Re: Objection to MP08_0244 MOD 1 Modification Request for Mixed Used Development at 23-37 Lindfield Avenue and 11 Havilah Lane, Lindfield

Drawing Title
BASEMENT 1 PLAN

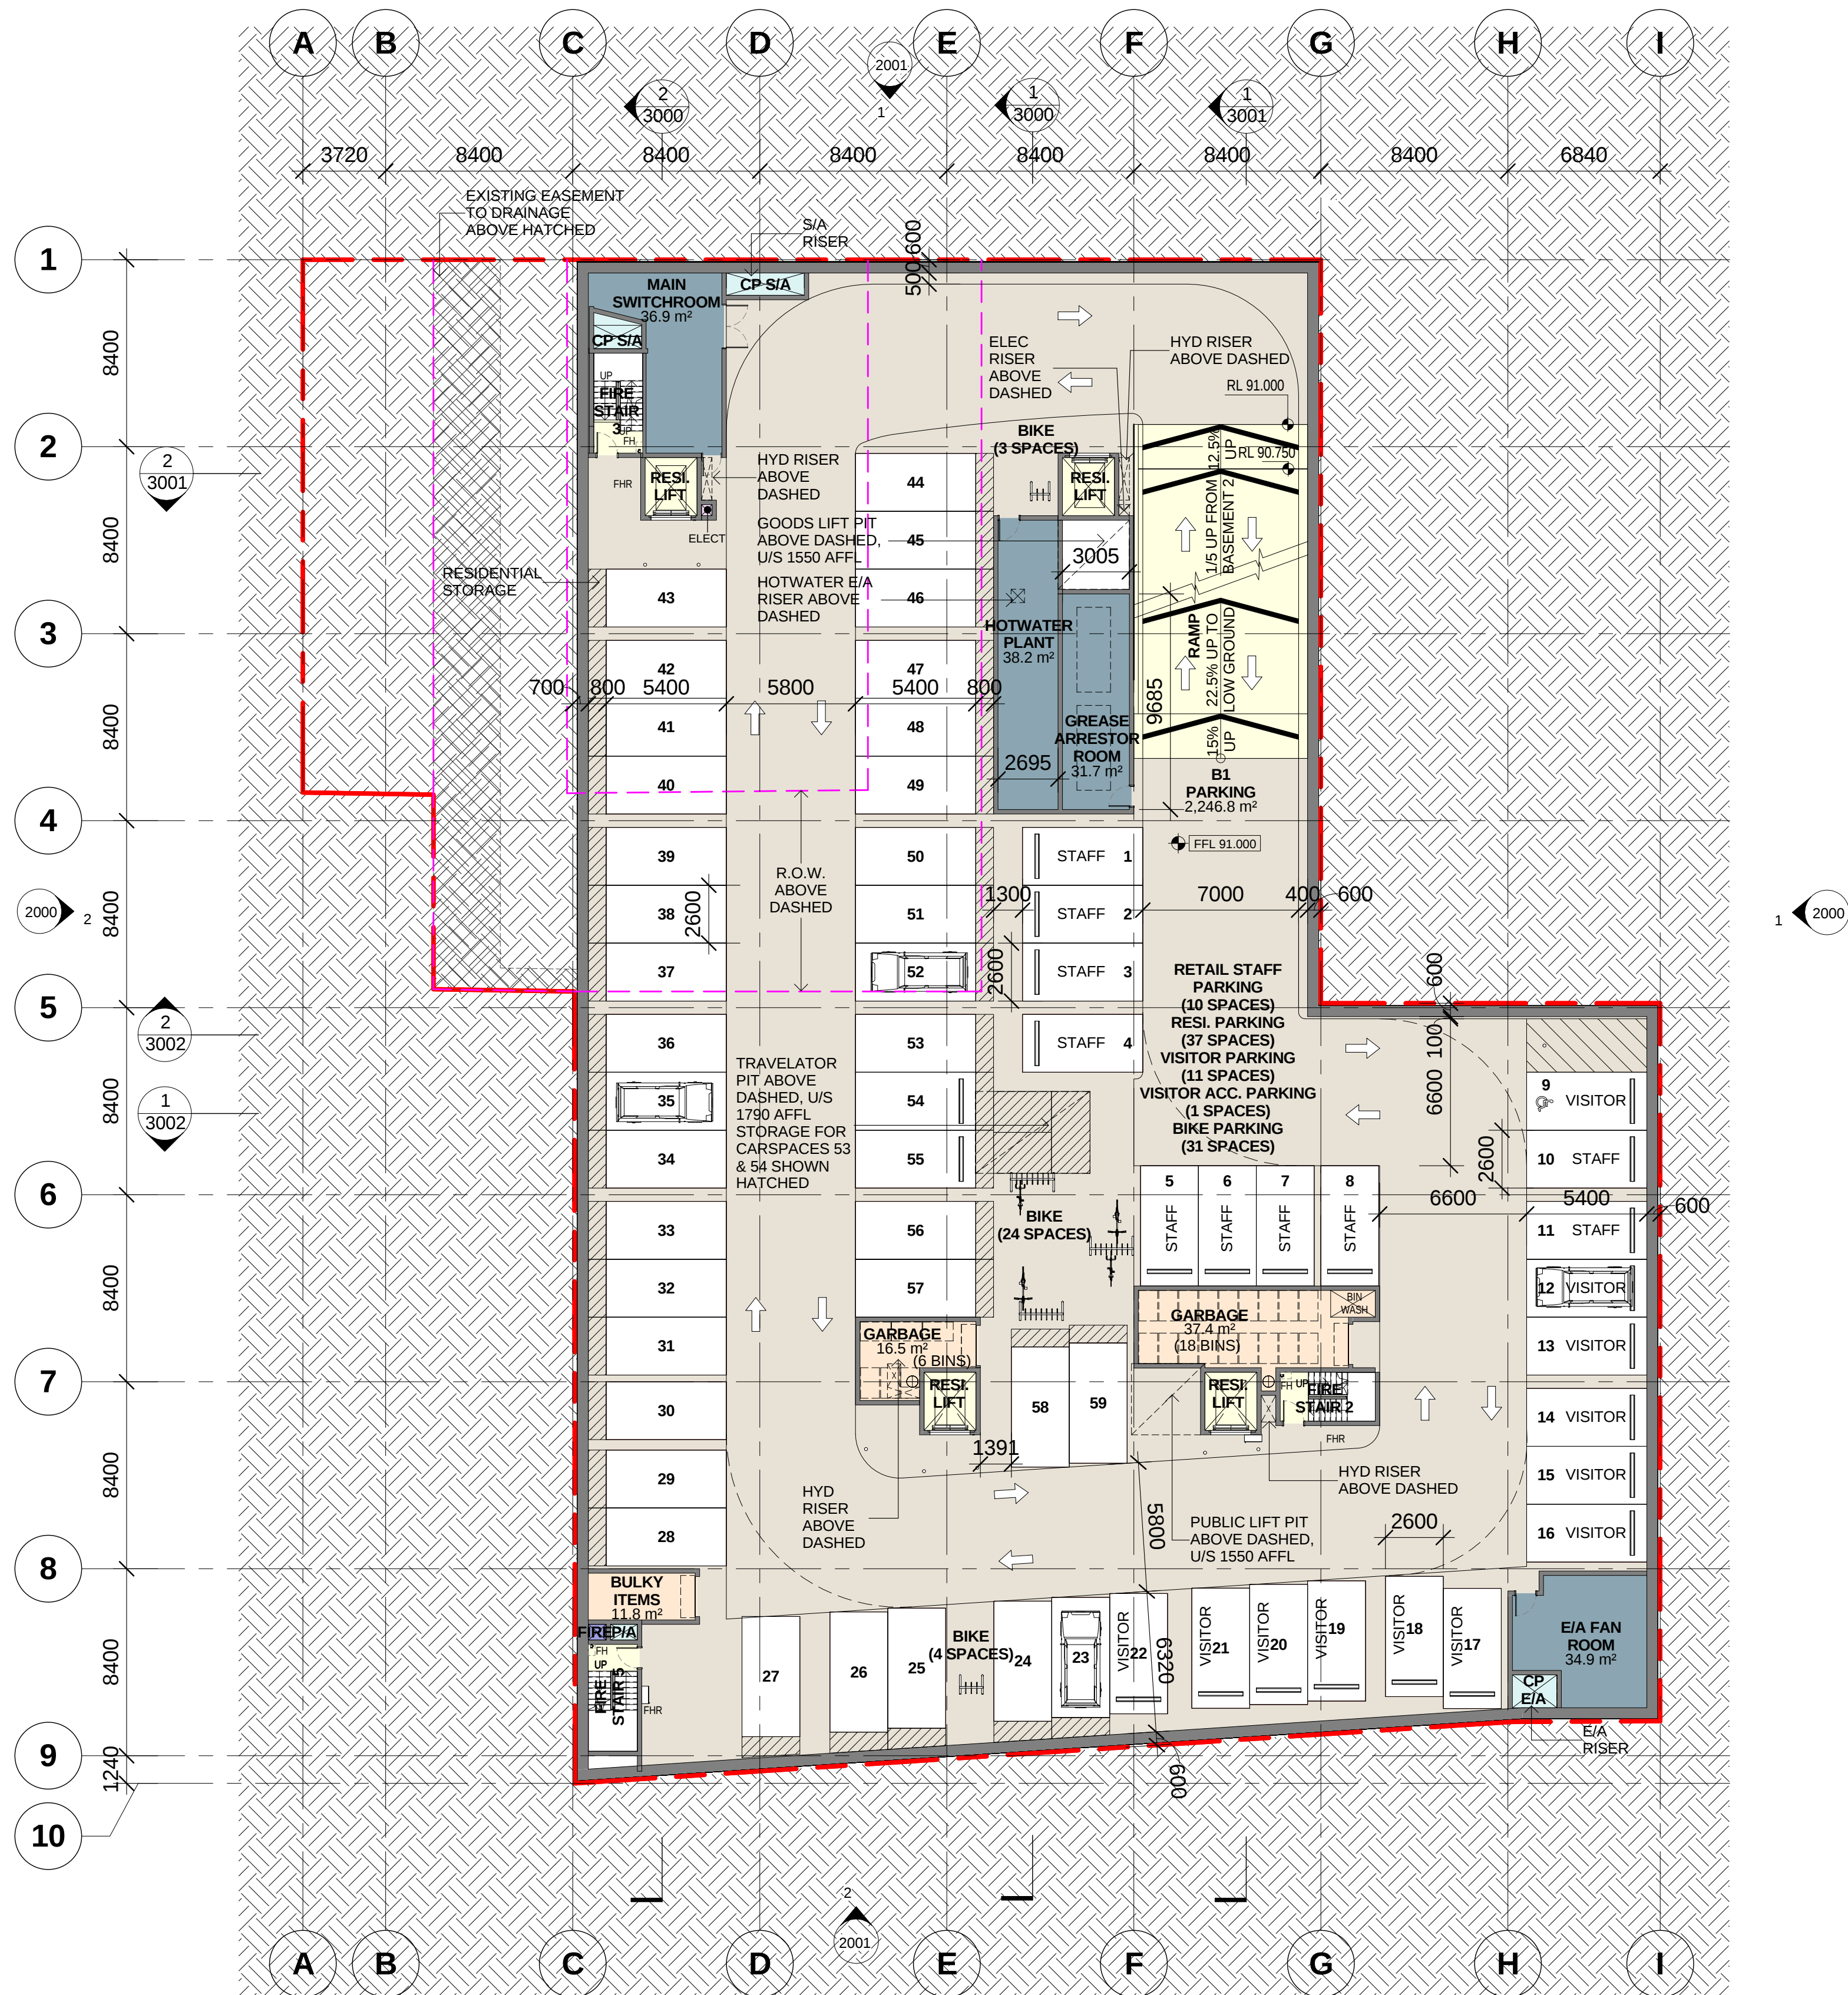
- Car spaces were identified as inadequate for the retail component and this has not been addressed relative to the remaining retail space proposed. The 25 car spaces counted as part of council's car park are also now highly uncertain due to the proposed rezoning and potential redevelopment.

ELEVATIONS

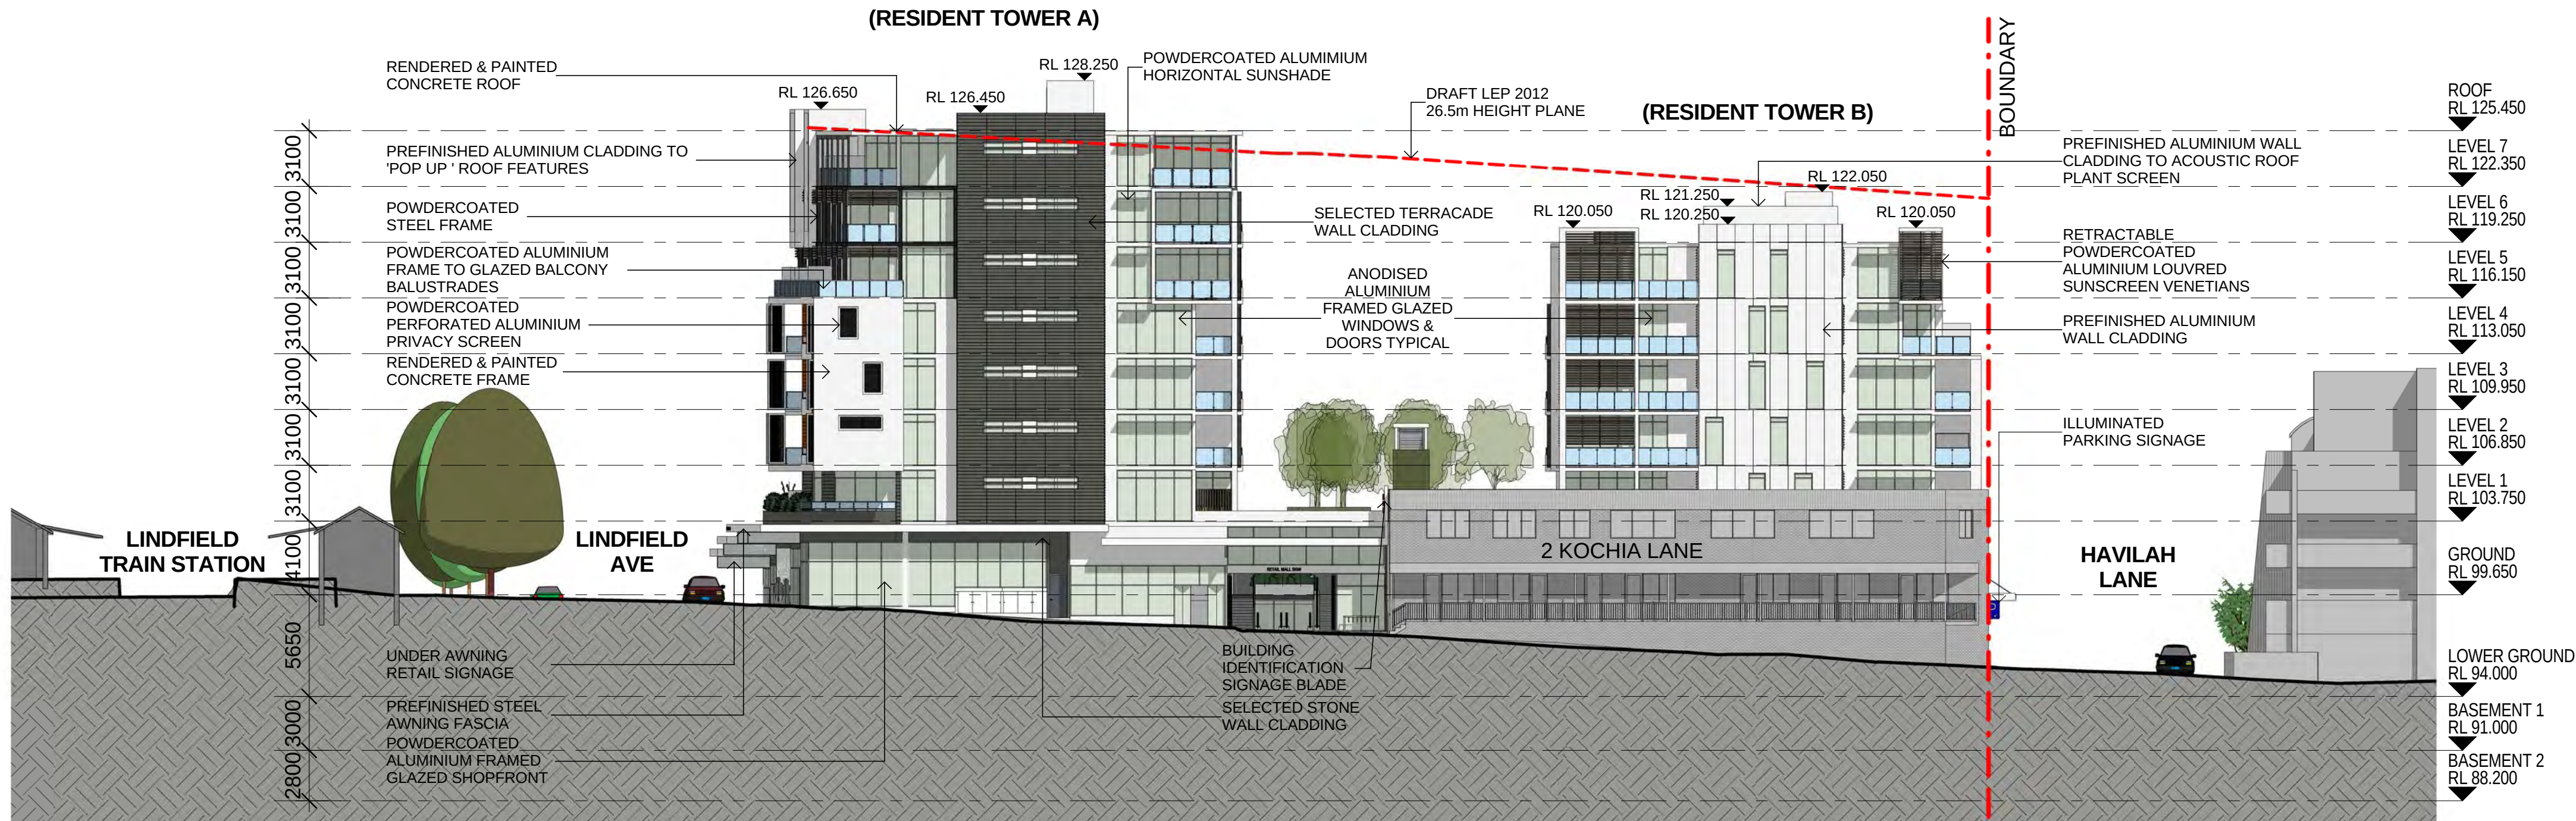
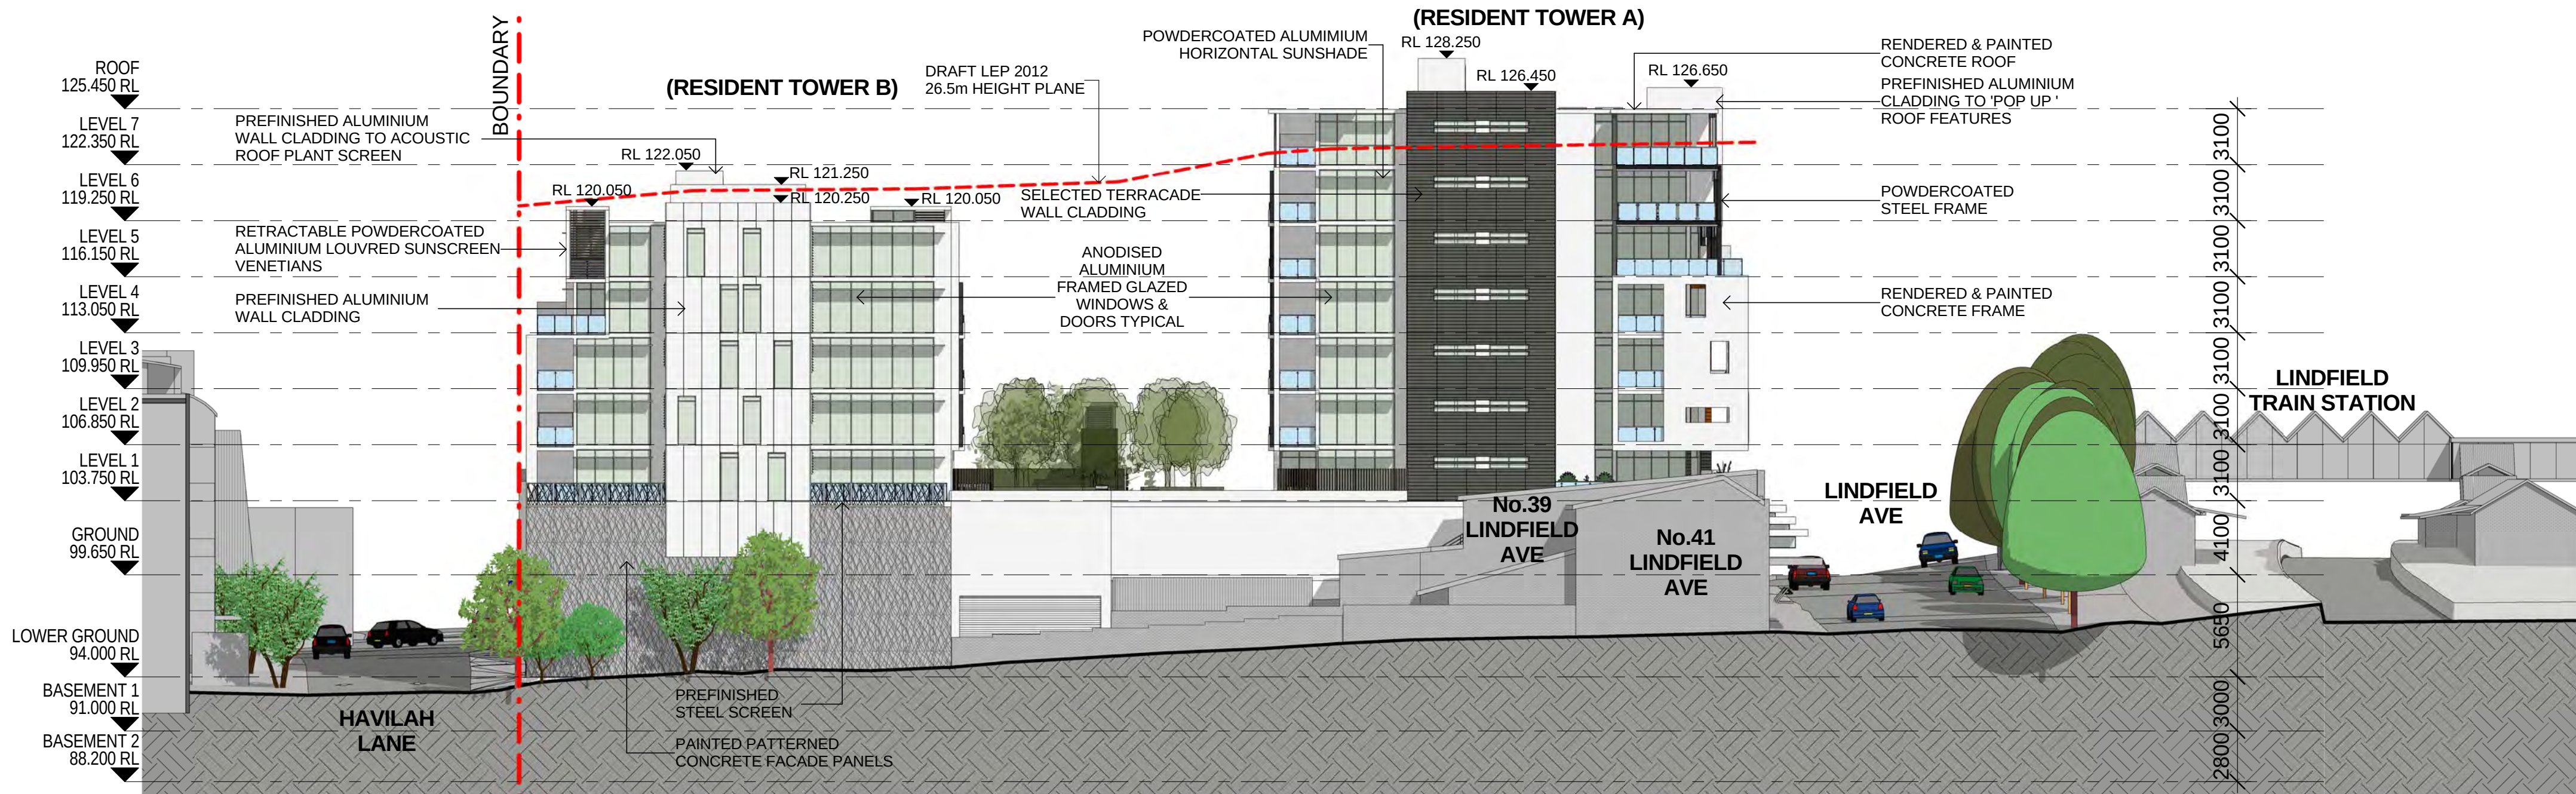
- The increase of an additional storey to both buildings: 8 storeys on Lindfield Avenue and 7 storeys on Havilah Lane creates excessive height and bulk and is out of character with the surrounding buildings, including the heritage listed adjacent building on Lindfield Avenue

- The additional storey (combined with less set back than the approved design) on Havilah Lane now creates privacy concerns for over 40 apartments in the adjacent 8 Havilah Lane, 8 Kochia Lane and 2-8 Milray Street residences
